From: Gary Ferrier [REDACTED]
Sent: 02 June 2017 16:51
To: Andrew Wood
Cc: Michael Lucas; Maggie Williams; Colin Begeman; Hamish Watson
Subject: RE: FG/198/16/PL - 1 Sea Drive

RE: FG/198/16/PL - 1 Sea Drive Ferring

Subject: FG/198/16/PL - 1 Sea Drive

PROJECT NO:	16/046
DWG. NO:	PL005

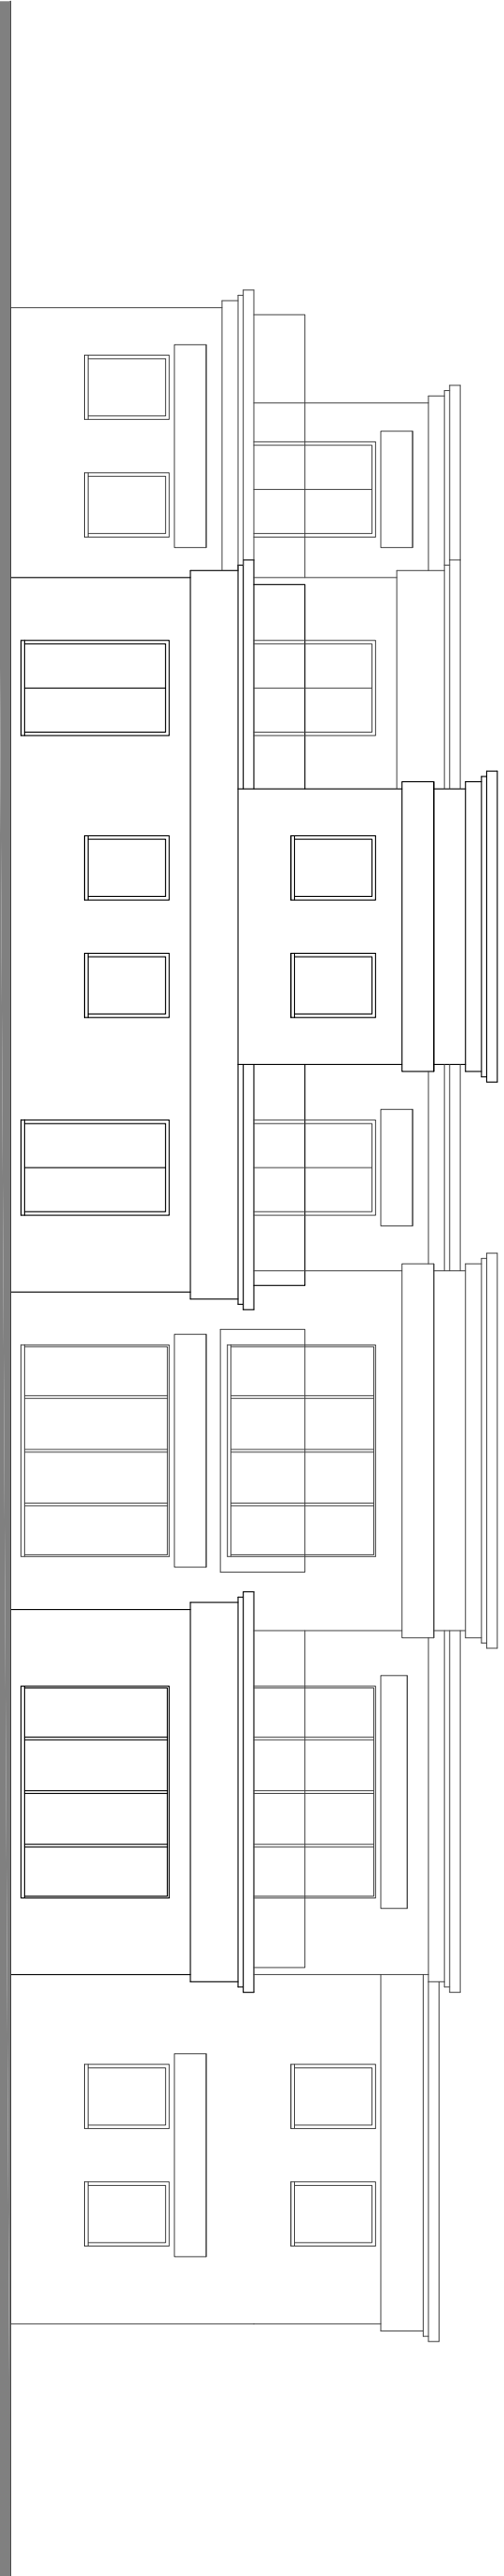
- 2) A supplementary plan showing the addition of the AOD level on the street scene to show that the following condition is complied with; in particular the AOD level of finished floor levels of 5.8 metres could be shown on the elevation plans. This is likely to be an important issue at planning committee.

- Finished floor levels are set no lower than 5.8m above Ordnance Datum (AOD).

This could be done by including the AOD level on the elevations.

1. Site Plan revised to show the 45 degree rule from the nearest window at No.3 Sea Drive and proposed FFL.
2. Elevations/Street scene drawing revised to show the proposed FFL.
3. A copy of the Bat Survey.
